Department of Planning and Environment

Subject: Greystanes Employment Lands - Dexu Estate Modification 7 (MP08_0259-Mod-7) - Request for additional information

Figure 11: Operational noise emissions

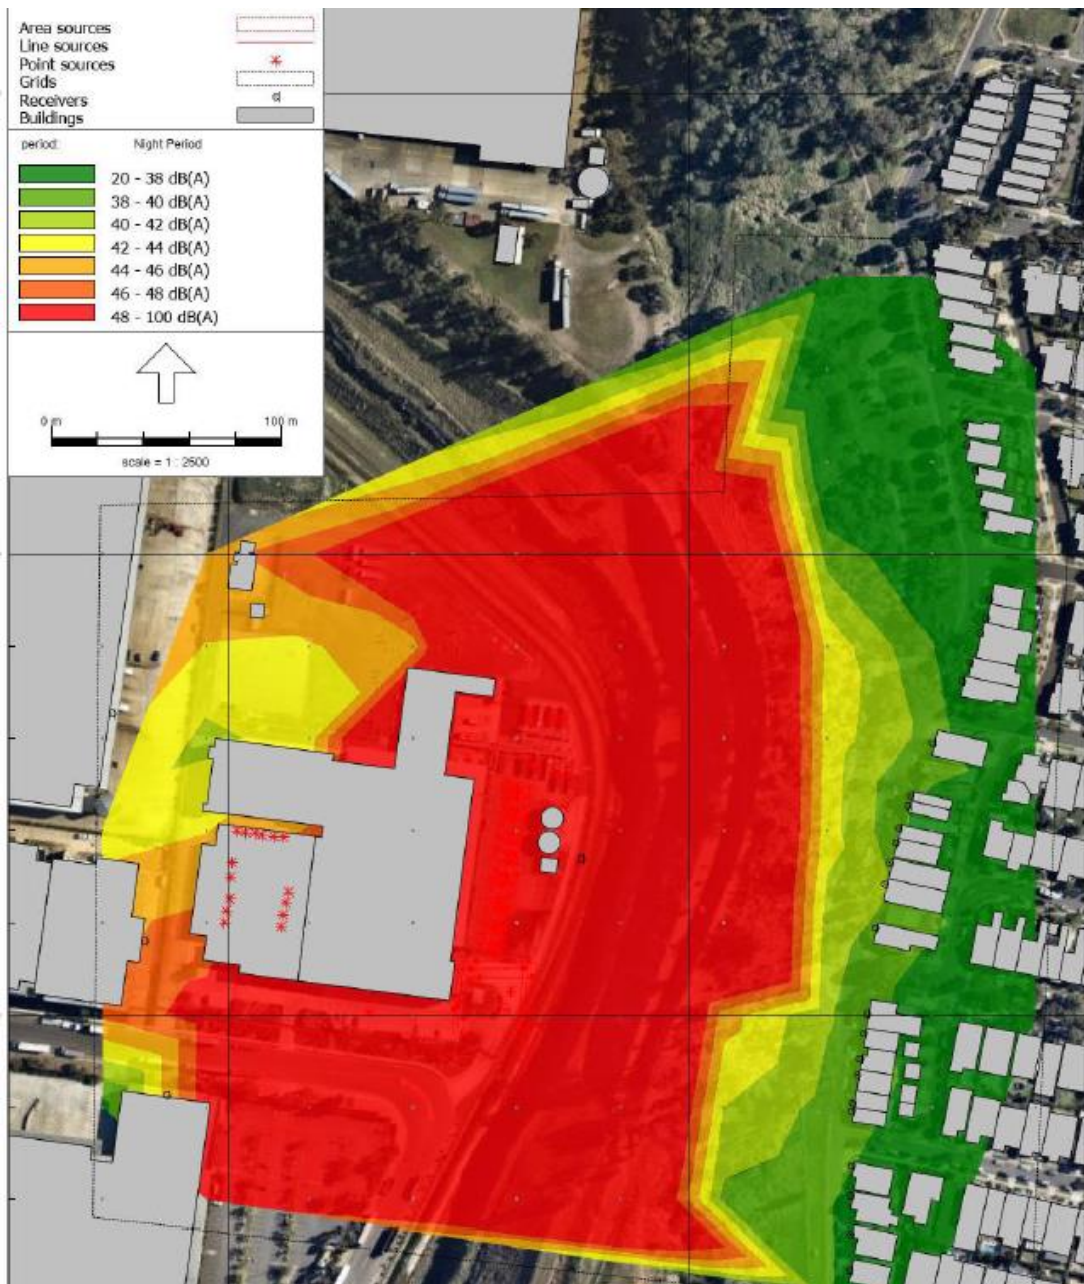
- The Department notes Section 5.2.3 of the Statement of Environmental Effects (SEE) describes a +1dB exceedance at receiver location R36 would occur during night time, in the event of a power outage with all generators including existing and proposed operating.
However, Section 5.1 of the Noise Impact Assessment (NIA) notes the exceedance would be from operation of chiller plant on the east of the project site. The Department understands the operation of the chiller plant is associated with a standard operating scenario. The Department requests clarification on the source of the +1dB exceedance.

Figure 3 Operational Noise Emissions – Worst Case 15-minute period (Night-time)

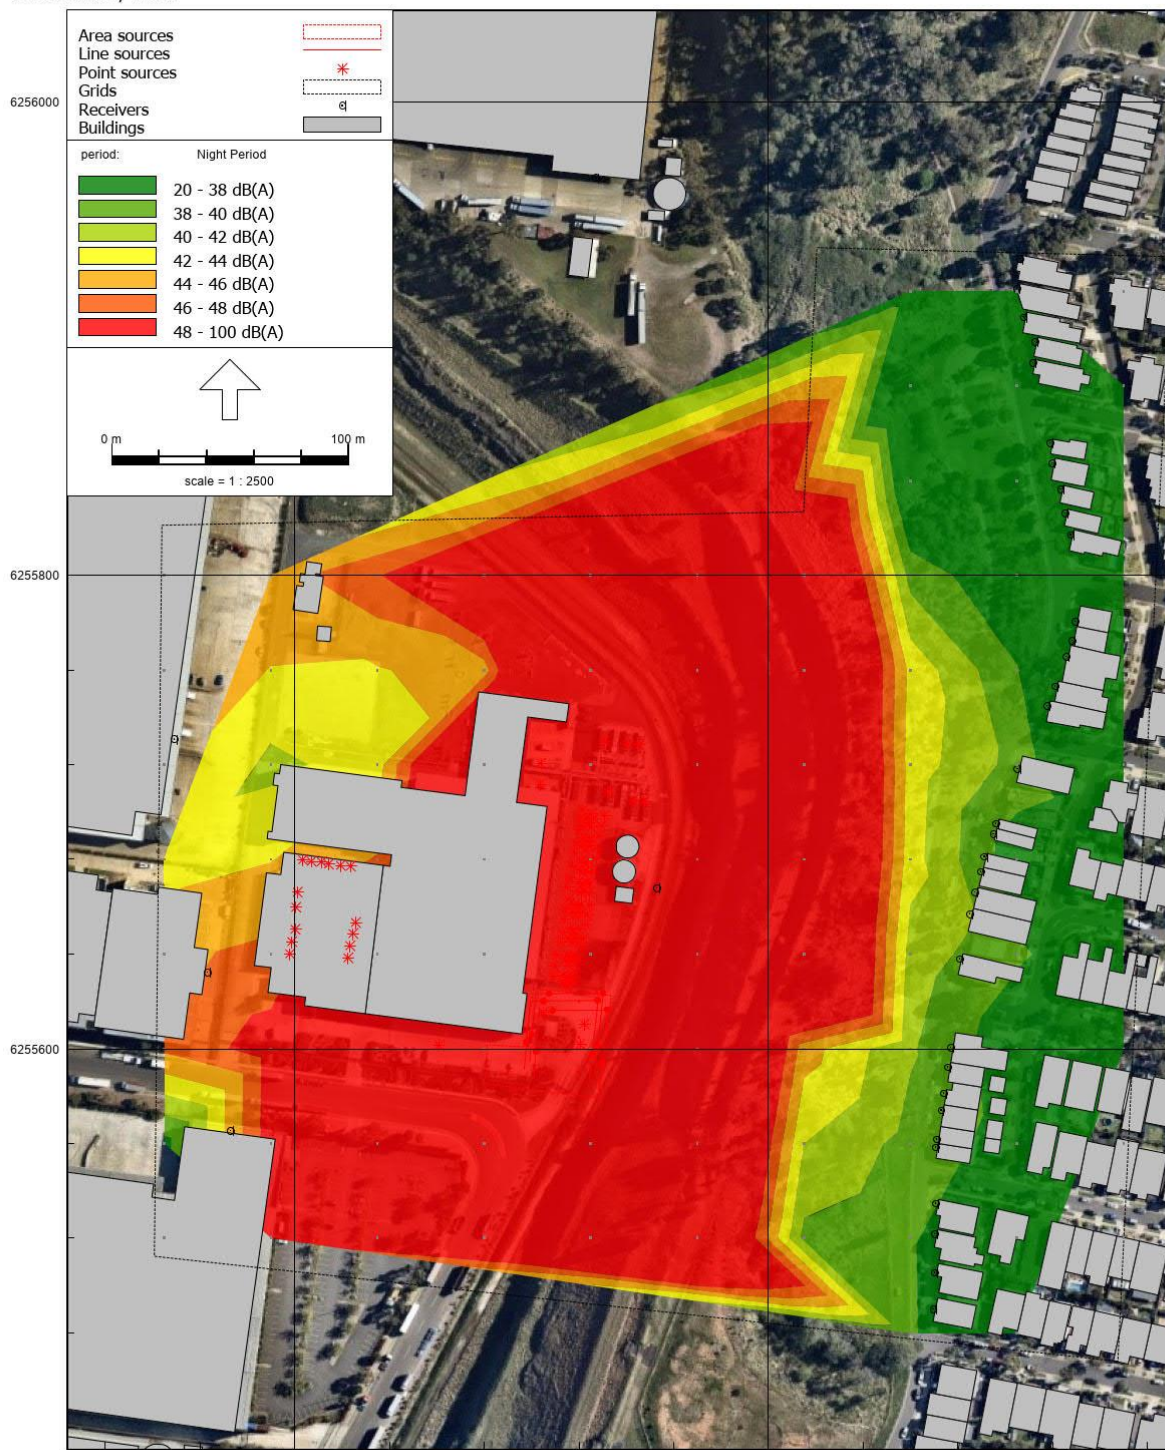
- Figure 3 of the NIA displays point, line and area noise source locations. However, it is difficult to identify all noise source locations due to the red colouring. Provide an updated Figure 3 with clearly identifiable noise source locations.
